Subject: **Modification Request for the Individual Section 404 and Section 10 Permits, Section 401 Water Quality Certification and CAMA Major Development Permit** for the Wilmington Bypass from US 17 in Brunswick County, north of the NC 87 intersection, to US 421 in New Hanover County. Federal Aid Project Nos. NHF-0017 (96) and STM-0017 (97), Division 3, TIP No. R-2633A&B.
Debit \$475 from WBS Element 34491.1.2

The purpose of this letter is to request modifications of the Section 404 Individual Permit, Section 10 Permit, Section 401 Water Quality Certification and CAMA Major Development Permit due to a change in jurisdictional impacts on Section A, Sites 31 and 32; and Section B Site 3 and Utility Site 2. Enclosed are revised Section A Permit Drawings 7, 8, 90, 91, 92, 93, 94 and 95 of 108, Section B Permit Drawings 2, 3 and 73 of 73 and Utility Drawings 3 and 15 of 15.

**PERMIT DRAWINGS**  
 SHEET 92 OF 108

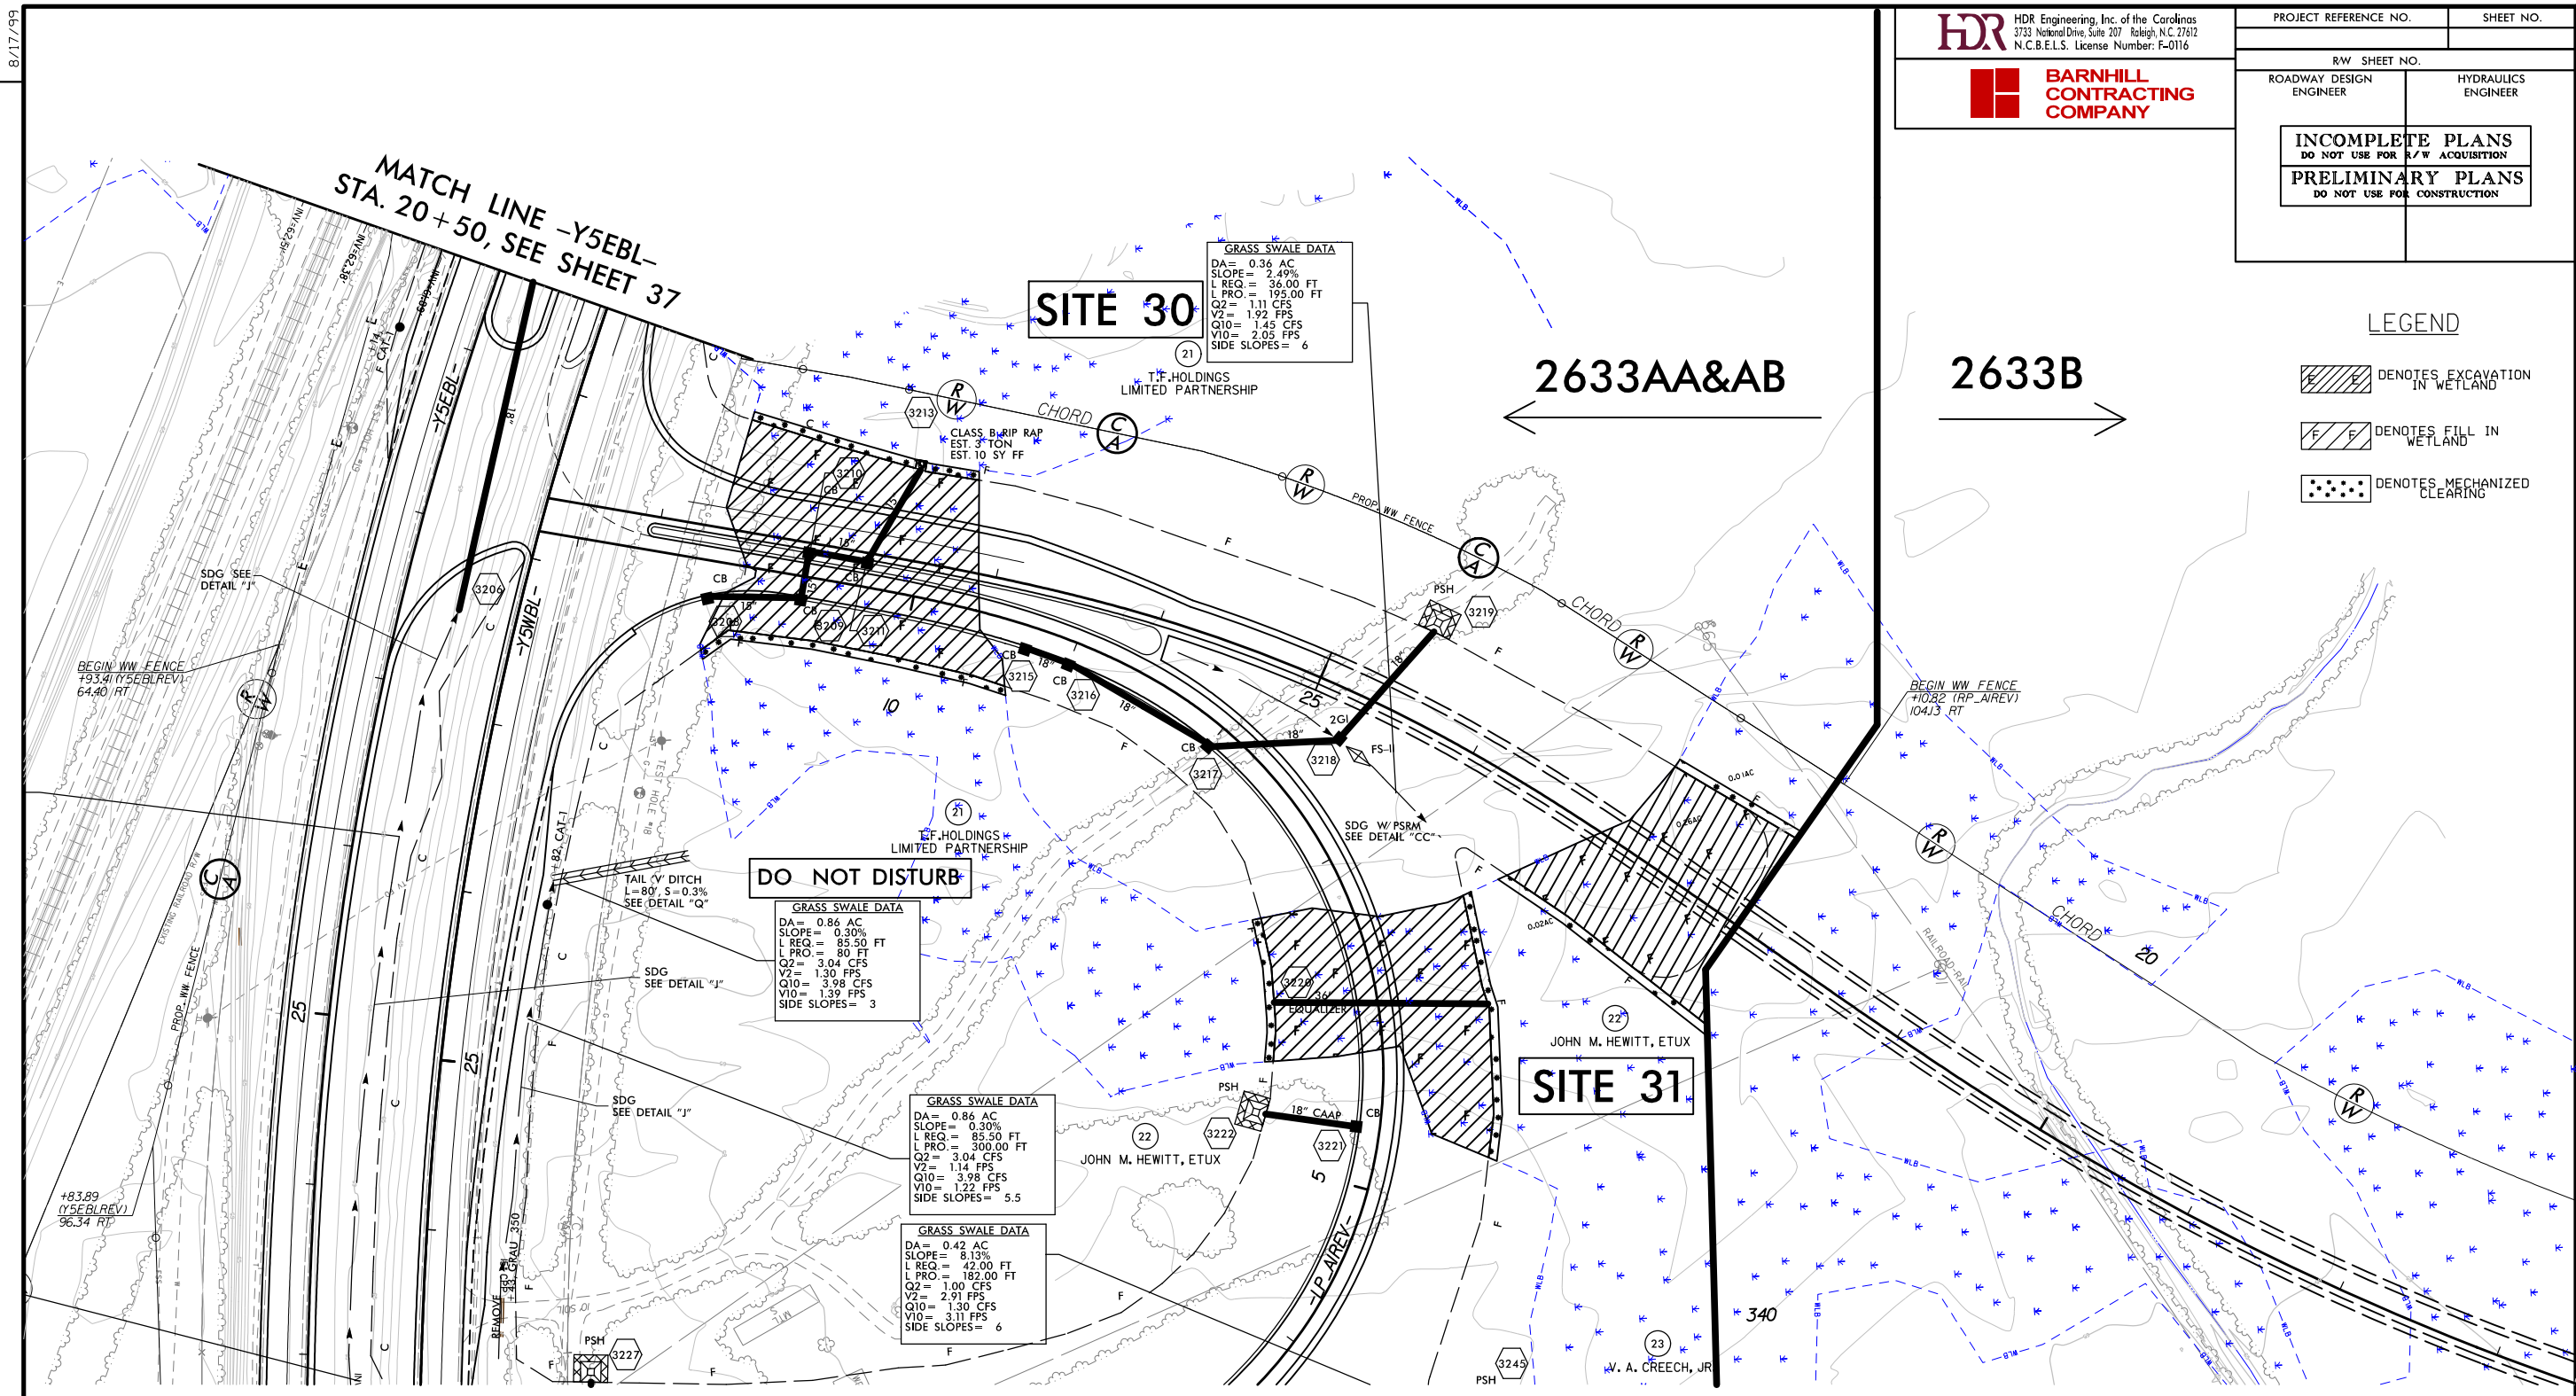
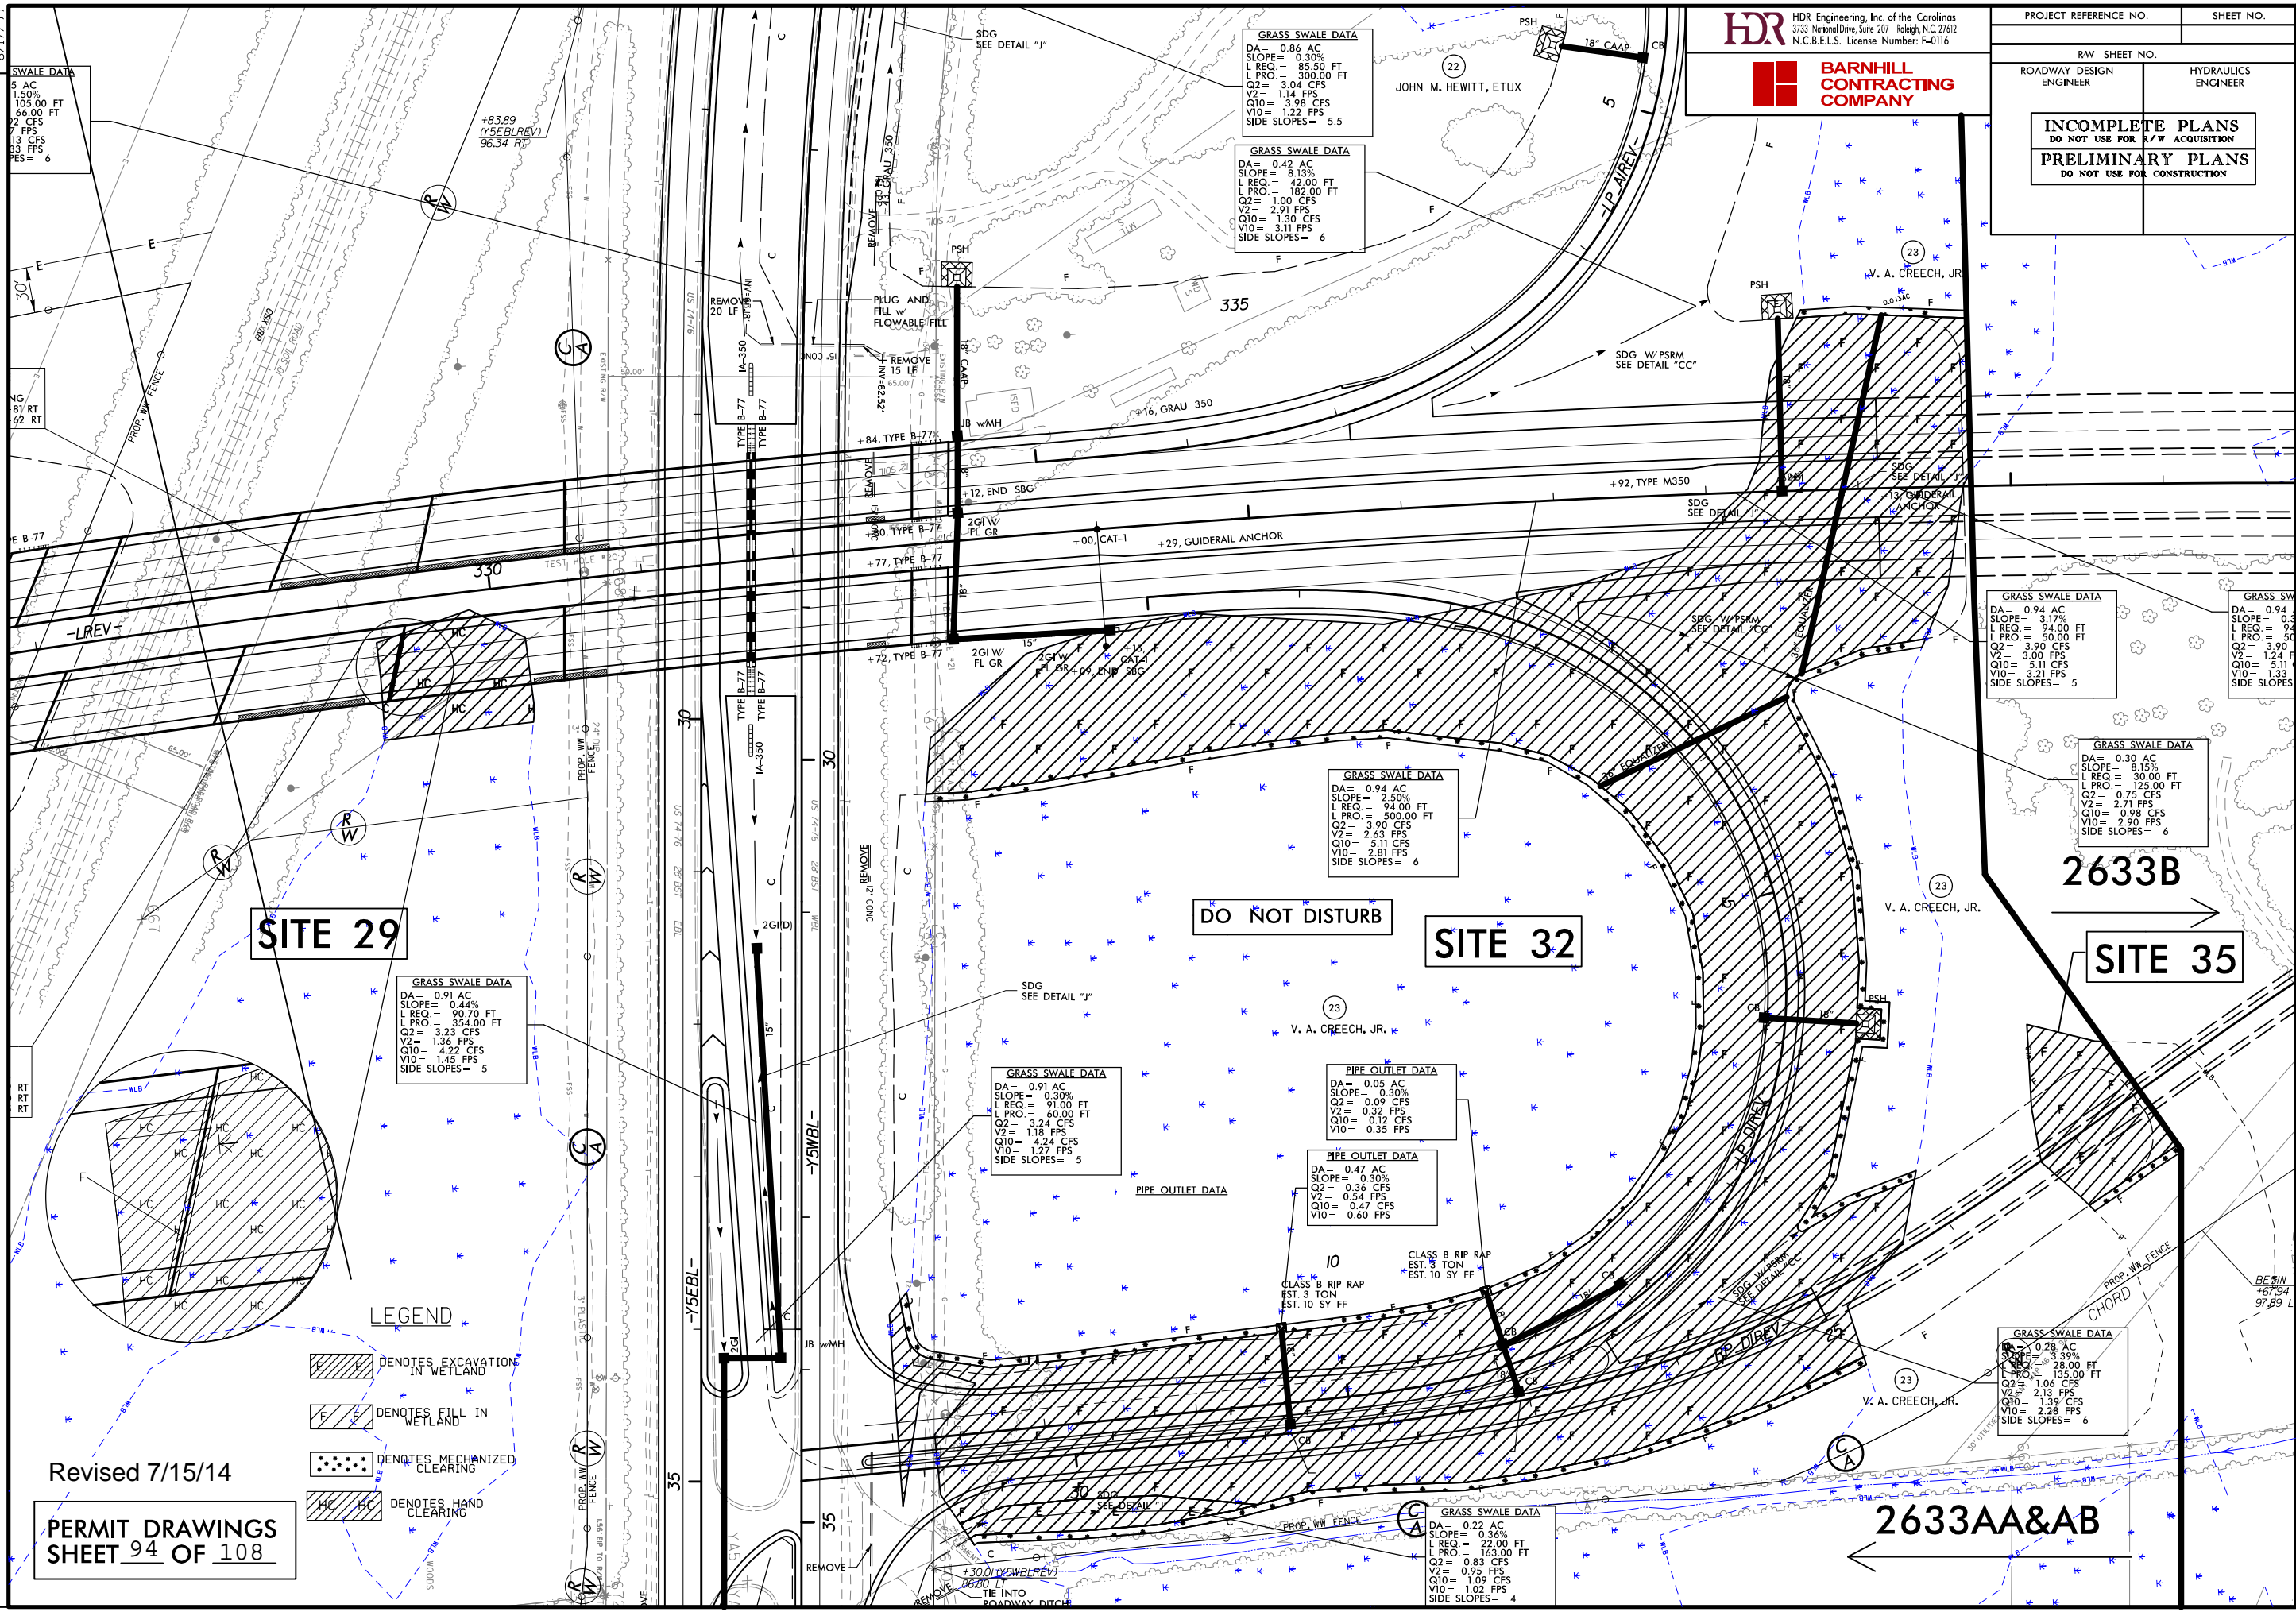
There is an increase in permanent fill of 0.02 acre of non-riparian wetlands. This is due to a wetland area not being on drawings as a result of a gap in coverage between Section A and Section B. The impact total for this site is now 0.61 acre.

There is an increase in permanent fill of 0.02 acre and 0.01 acre of mechanized clearing in non-riparian wetlands. This is due to wetland area not being on drawings as a result of a gap in coverage between Section A and Section B. The impact total for this site is now 4.65 acres.

Permit Drawing 2 of 73  
Revised 7/15/14

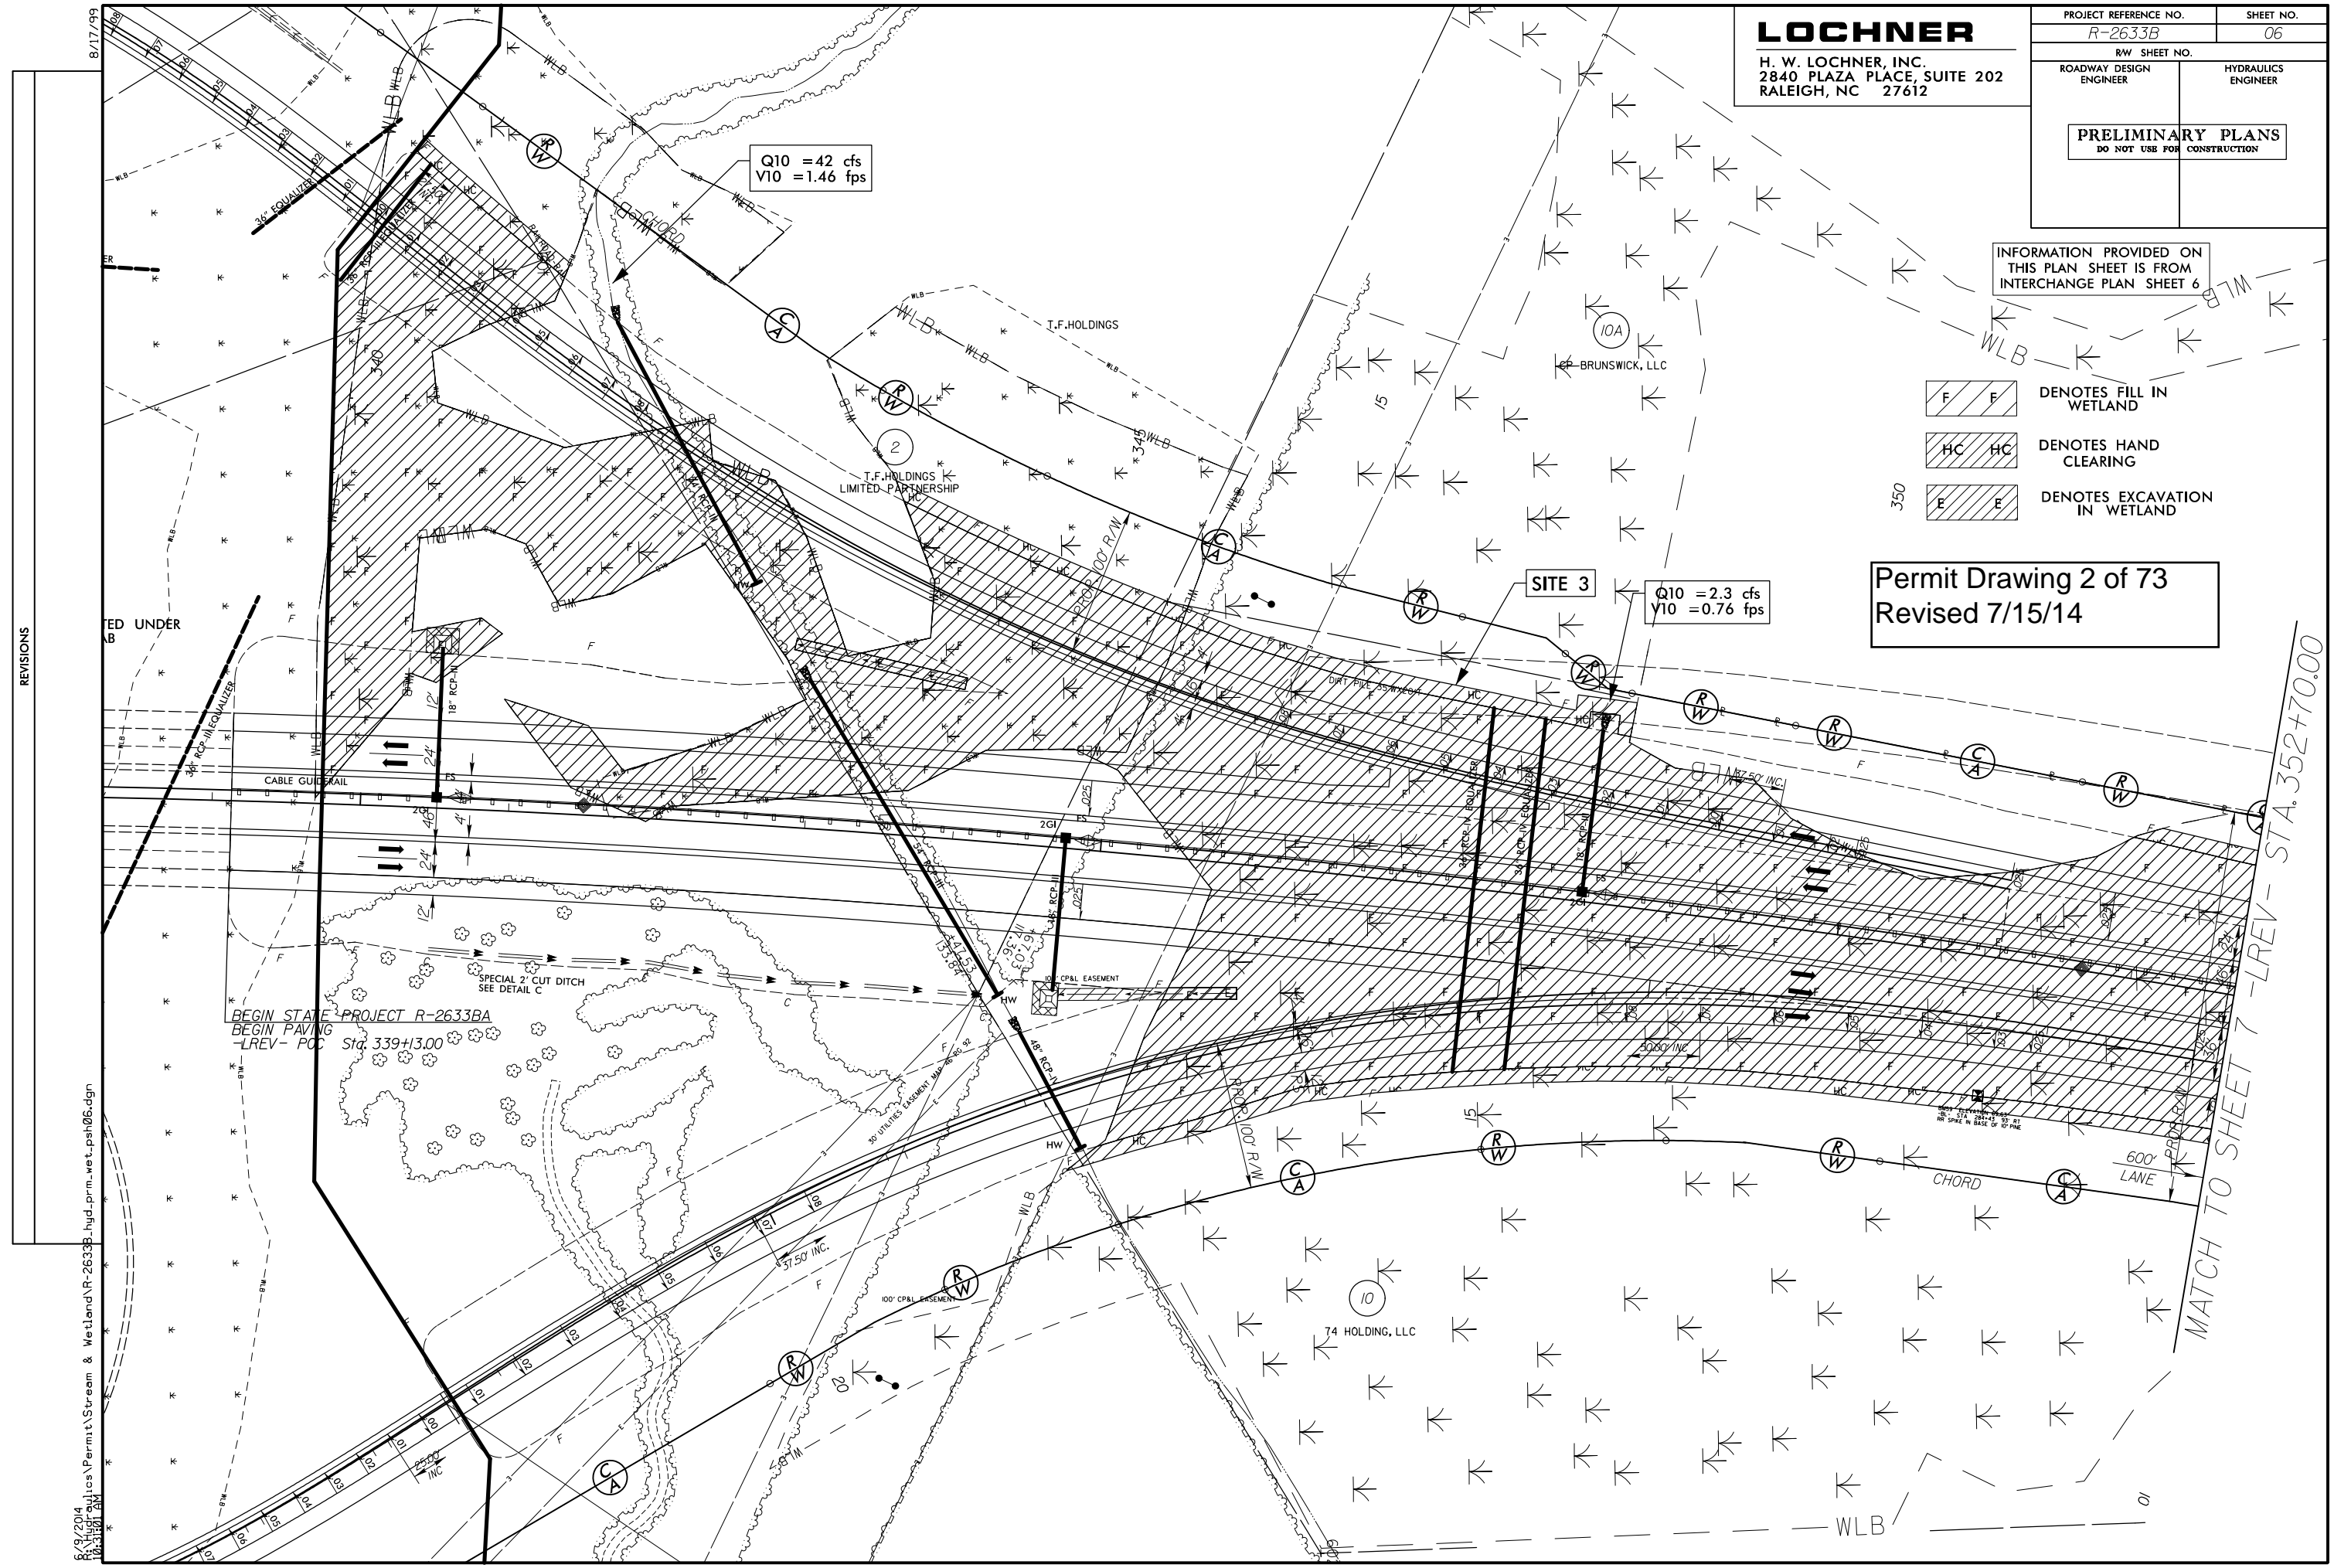
Non-riparian wetland impacts have increased at this site by 0.06 acre. This is due to discrepancy of some wetland area not being on drawings. This is due to wetland area not being on drawings as a result of a gap in coverage between Section A and Section B. The new riparian wetland total for Site 3 is 7.51 acres.
